Reinforcement to the North Shropshire Electricity Distribution Network

Document Reference: 6.6.7
Environmental Statement Appendix 6.7
LVIA Scoping Opinion Responses

APPENDIX 6.7: LANDSCAPE AND VISUAL ASSESSMENT RESPONSE TO SCOPING OPINION

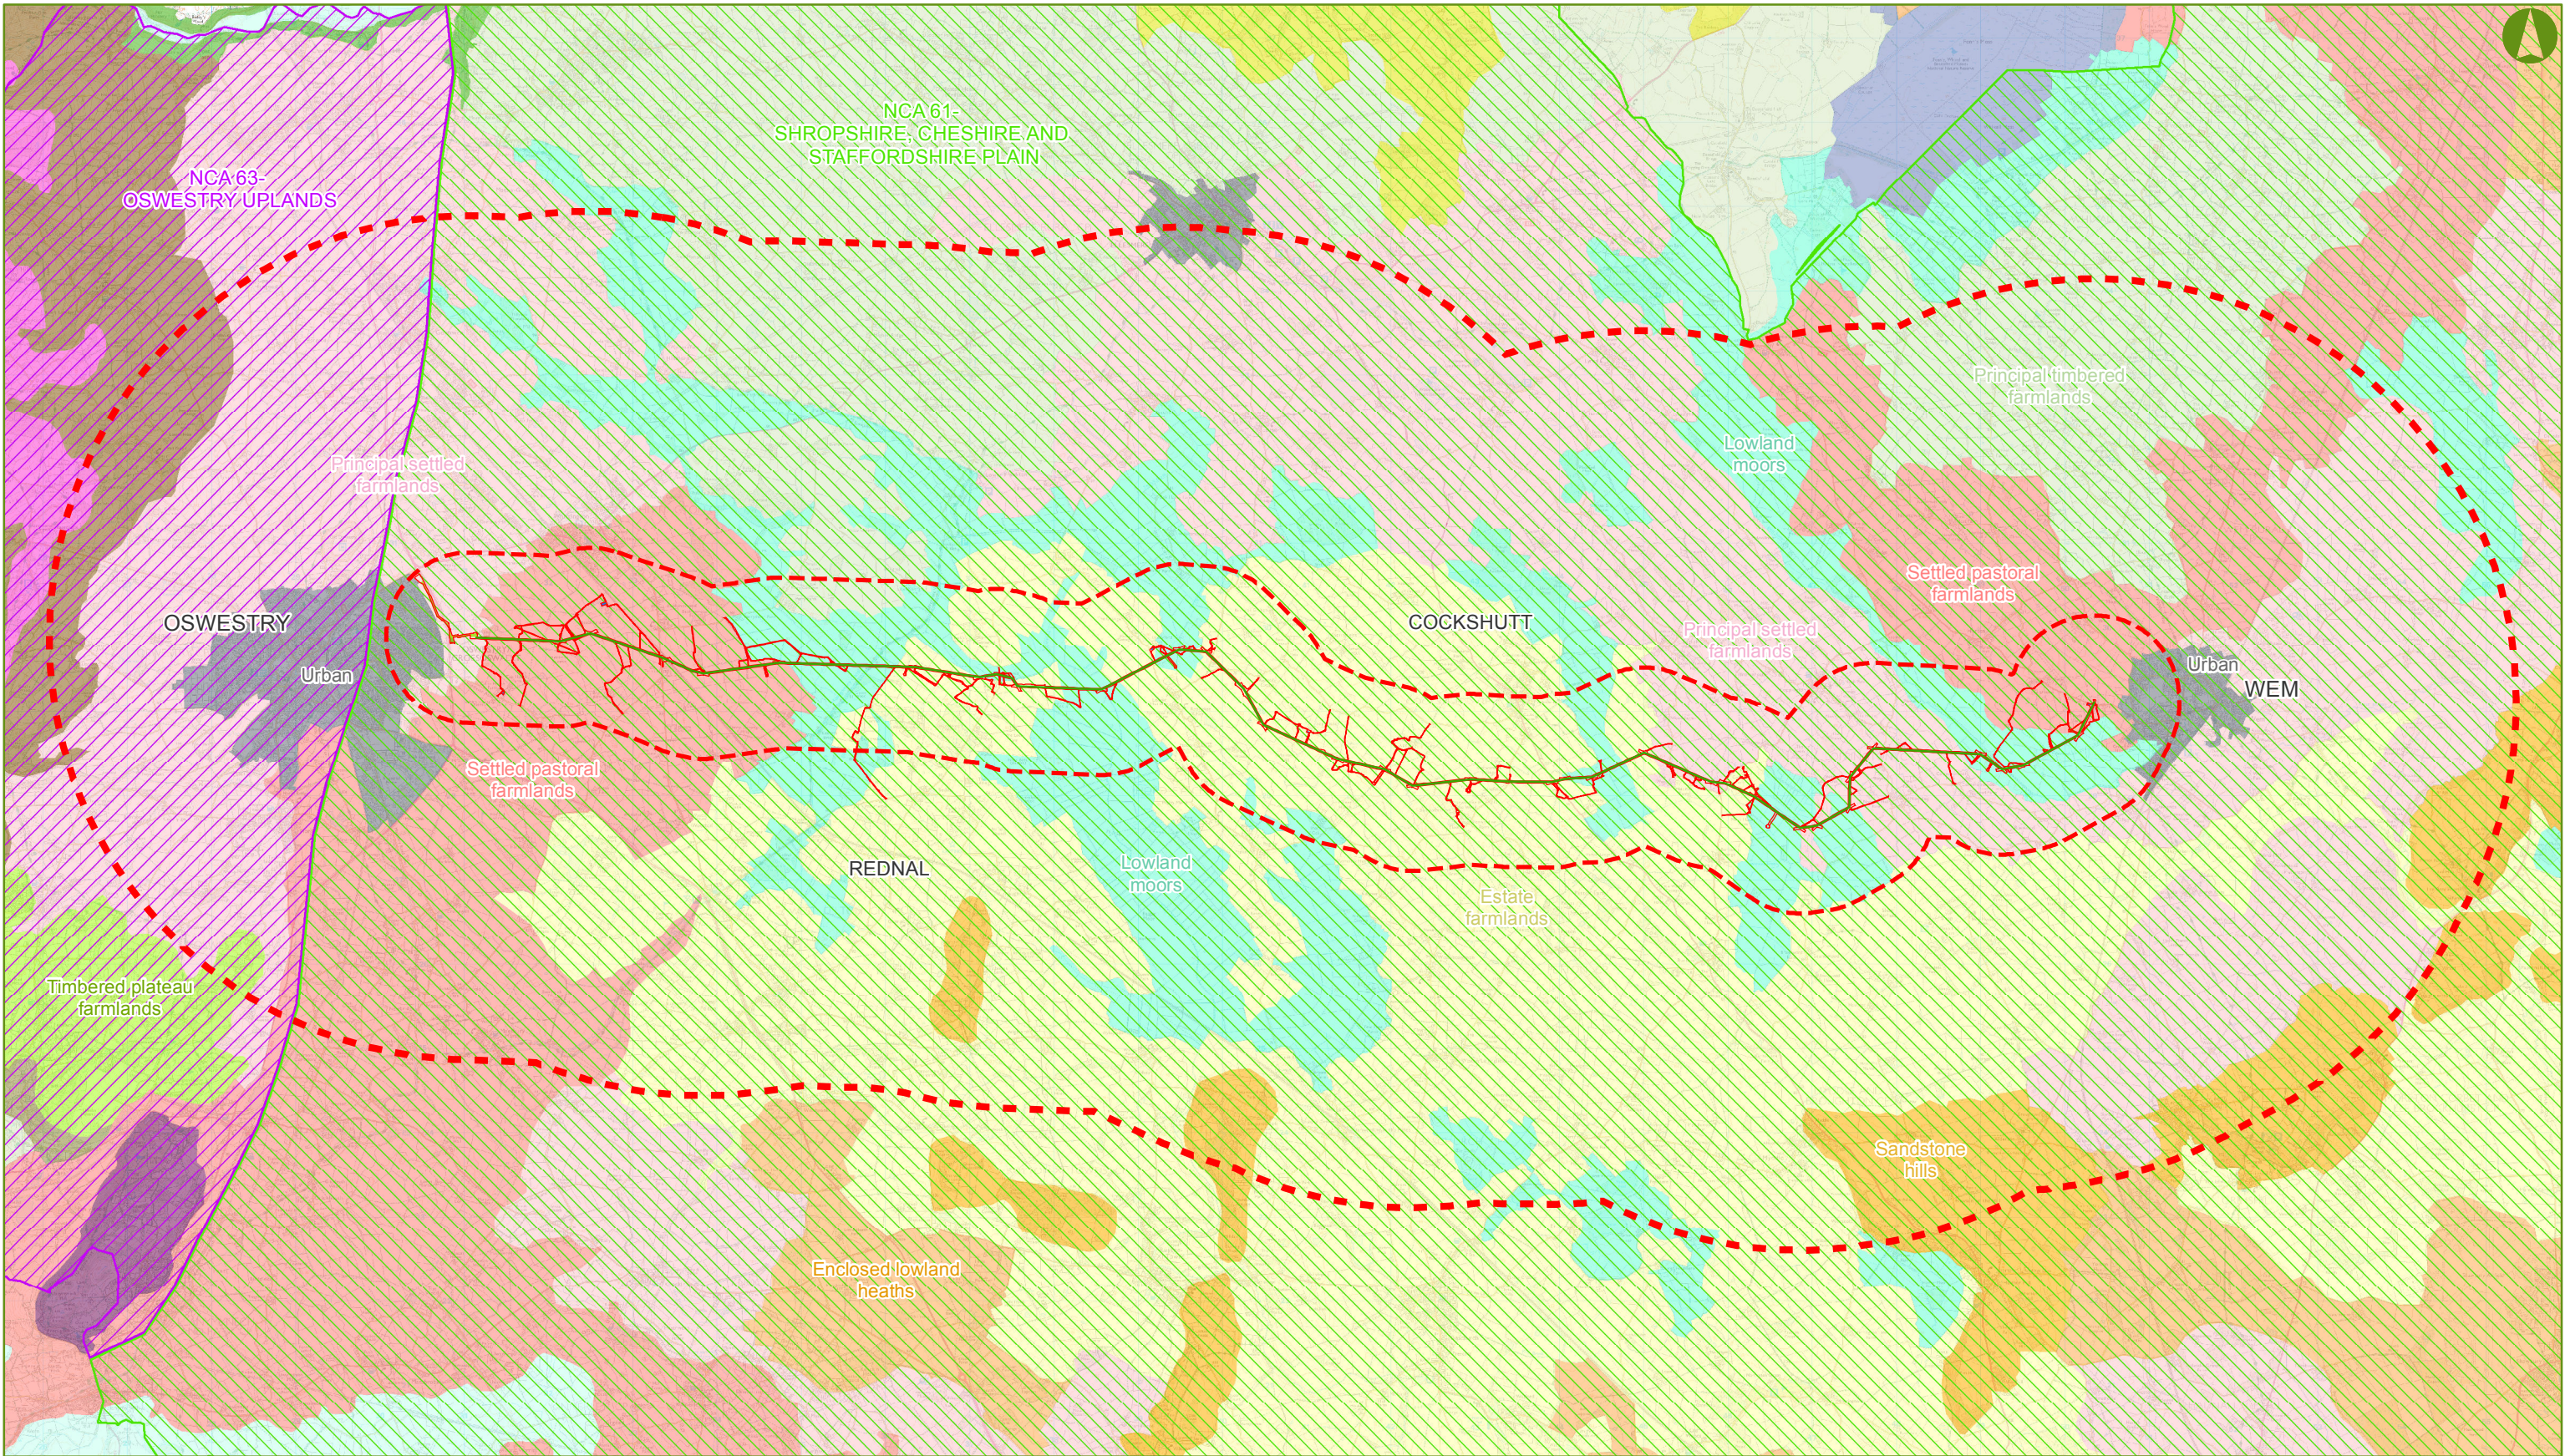
3.43	The Scoping Report identifies that the same 1km and 5km study areas are to be used for the landscape and the visual assessments. A number of references are made in the Landscape topic chapter to the study area, however it is not always clear whether the reference is to the 1km or the 5km study area. This should be explicit in the ES.	The study areas are defined in Section 6.3 of Chapter 6 ‘Landscape and Visual’ (DCO Document 6.6) and illustrated on Figure 6.1 ‘LVIA Study Areas’ (DCO Document 6.14) of the ES.

3.44	The Landscape topic chapter of the Scoping Report explains the reasoning for defining a 1km and 5km study area from the proposed overhead line route (paragraphs 7.7.7 – 7.7.8). While the explanation for the choice of the 1km study area is understood by the SoS it is not clear why 5km is considered an adequate distance in which to capture long-distance views. The Applicant may find it helpful to refer to the zone of visual influence (ZVI) of the proposed development when defining the study area in the ES.	The study areas are defined in Section 6.3 of Chapter 6 ‘Landscape and Visual’ (DCO Document 6.6) and illustrated on Figure 6.1 ‘LVIA Study Areas’ (DCO Document 6.14) of the ES.

3.46	Paragraph 7.5.11 of the Landscape topic chapter notes that the nearest Area of Outstanding Natural Beauty (AONB) is the Clwydian Range (Bryniau Clwyd), which is 8km northwest of the Proposed Development. The Applicant should ensure that the study area for this topic is sufficiently broad to encompass any AONBs (or other relevant features) which could be affected by the Proposed Development, or that the reasoning is provided in the ES for excluding any such features.	The Clwydian Range AONB will not be affected by the Proposed Development. The study areas are defined in Section 6.3 of Chapter 6 ‘Landscape and Visual’ (DCO Document 6.6) and illustrated on Figure 6.1 ‘LVIA Study Areas’ (DCO Document 6.14) of the ES.

Document Title: CHAPTER 6: LANDSCAPE AND VISUAL FIGURE 6.3 LANDSCAPE CHARACTER AREAS

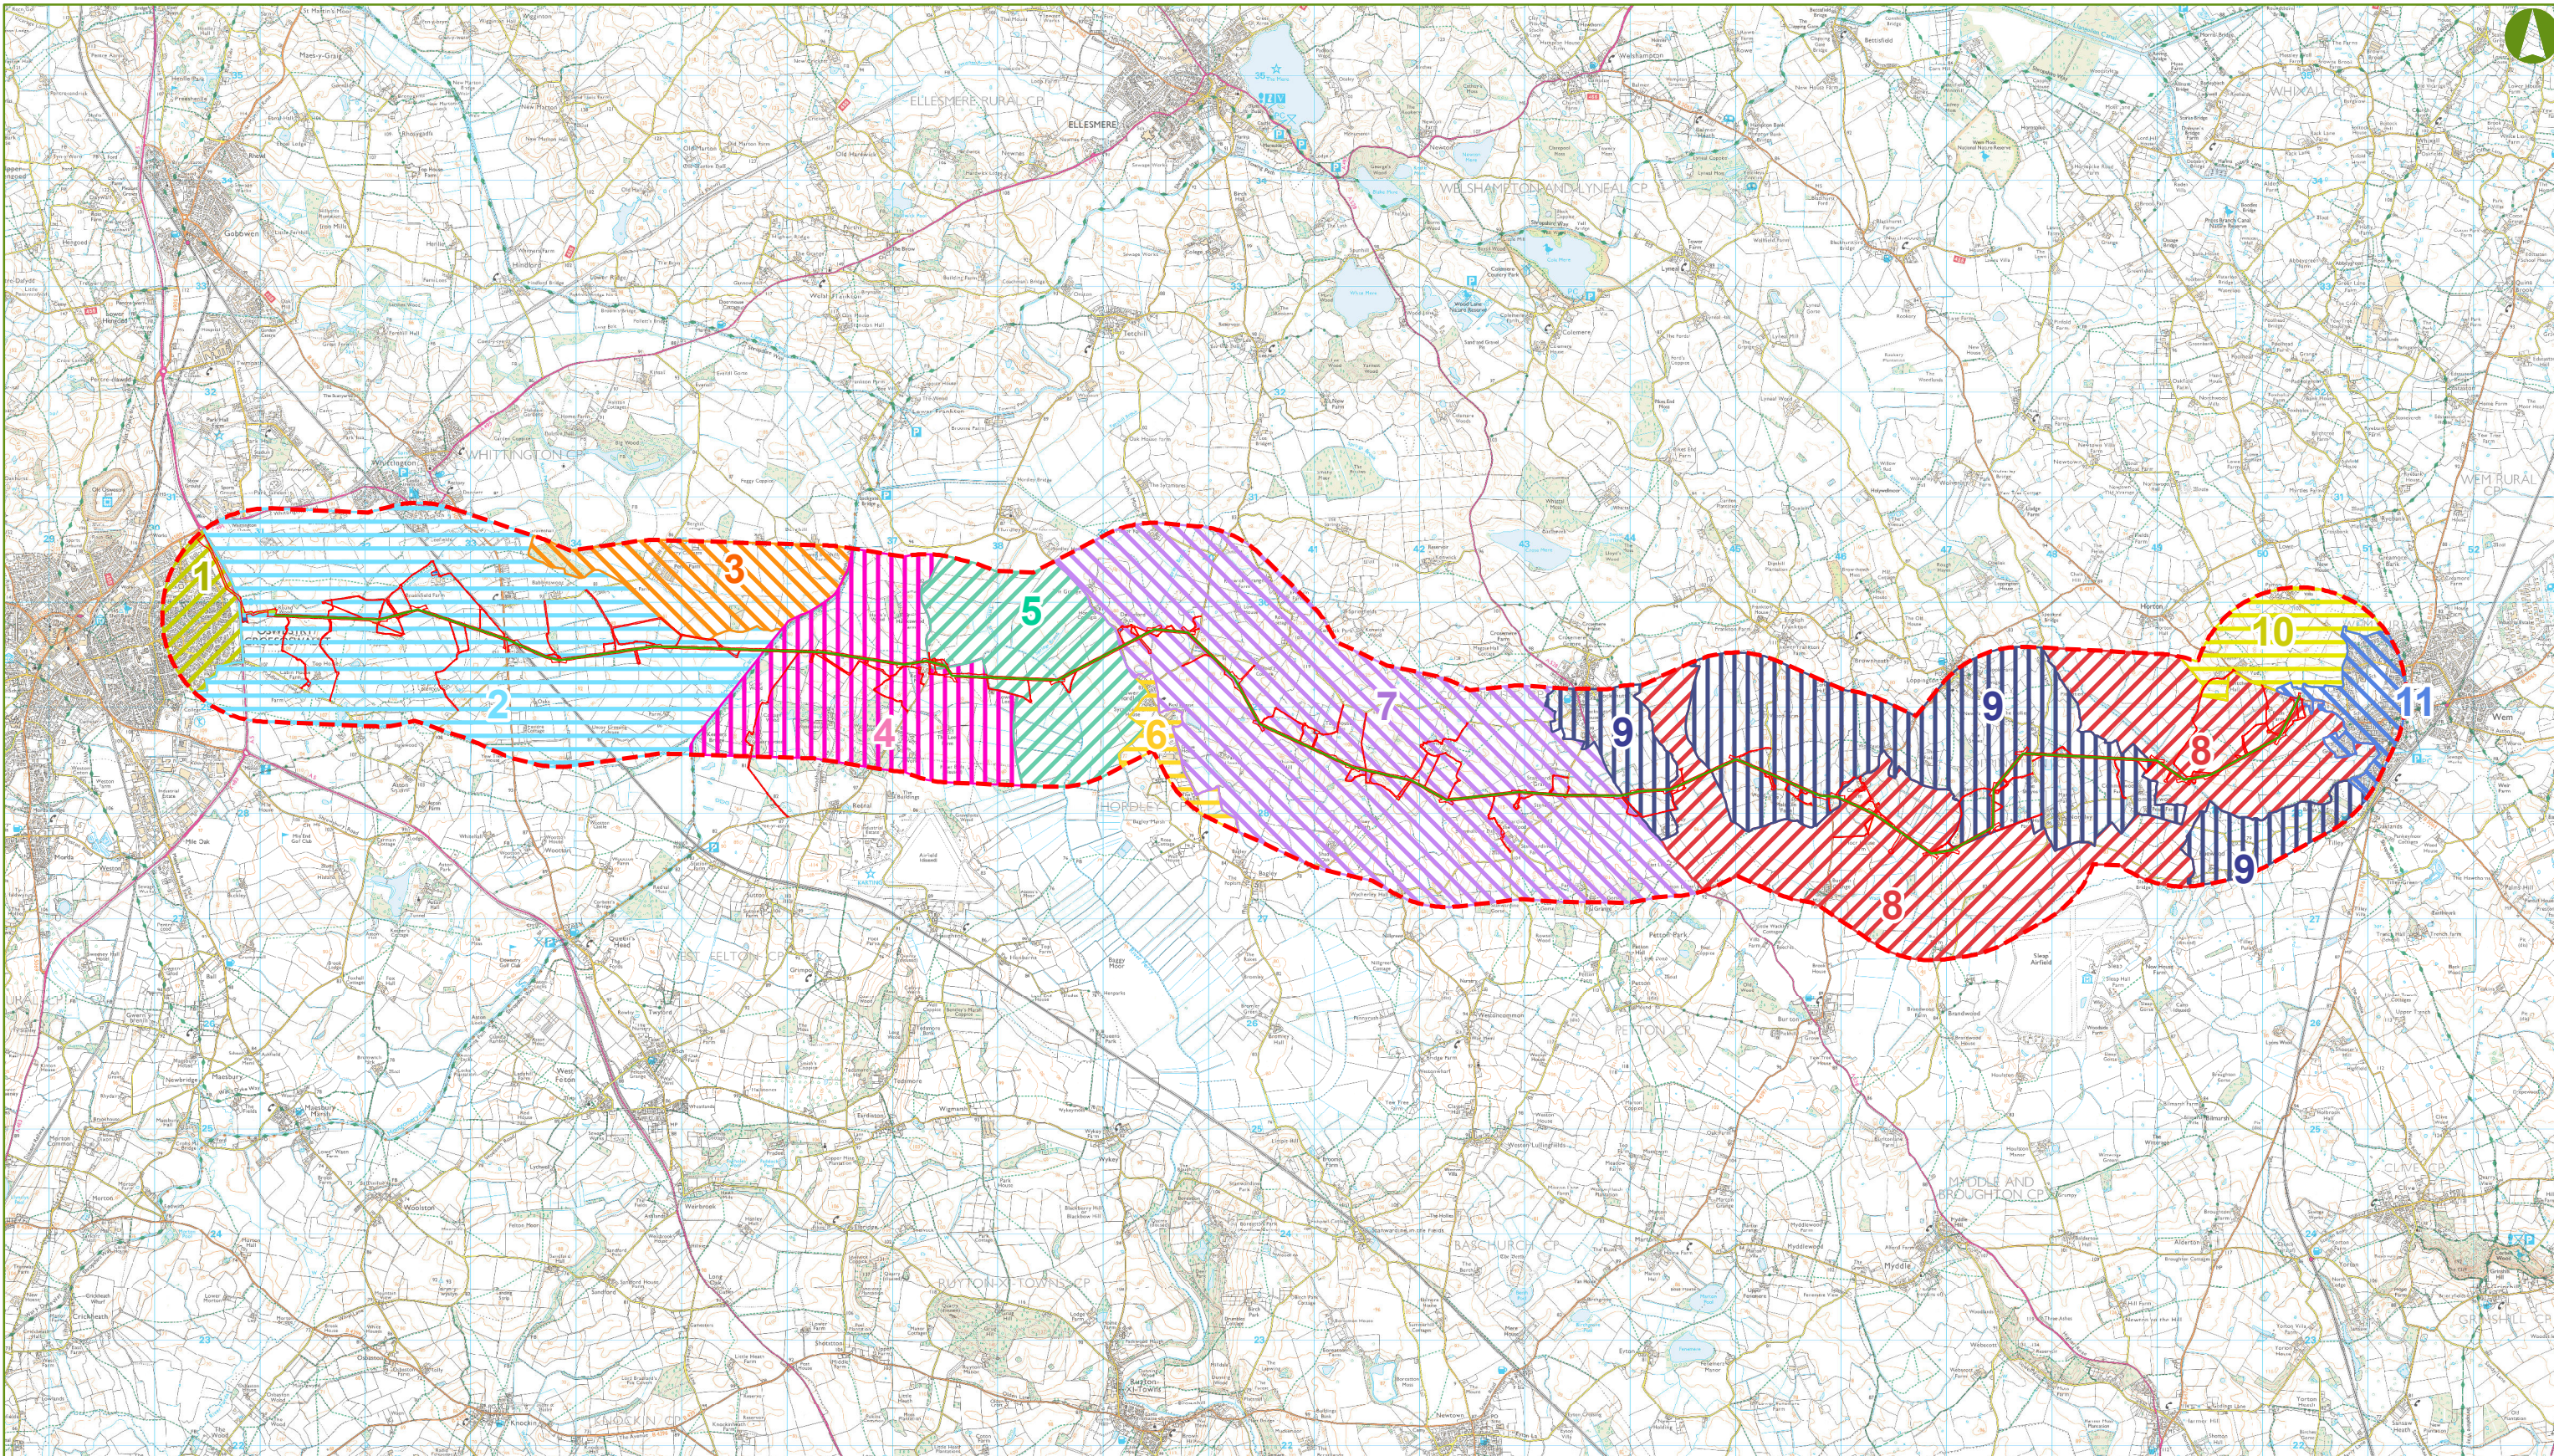
3.32	The SoS notes the proposed use of the Guidelines for Landscape and Visual Assessment third edition (GLVIA3).	Noted.
3.33	The SoS notes the intention to use local Landscape Character Areas to determine the baseline situation. The Applicant should also give consideration to the effects on national landscape character areas.	The assessment of the Shropshire, Cheshire and Staffordshire Plain National Character Area (NCA 61) is presented in Appendix 6.2 (DCO Document 6.6.2) of the ES.
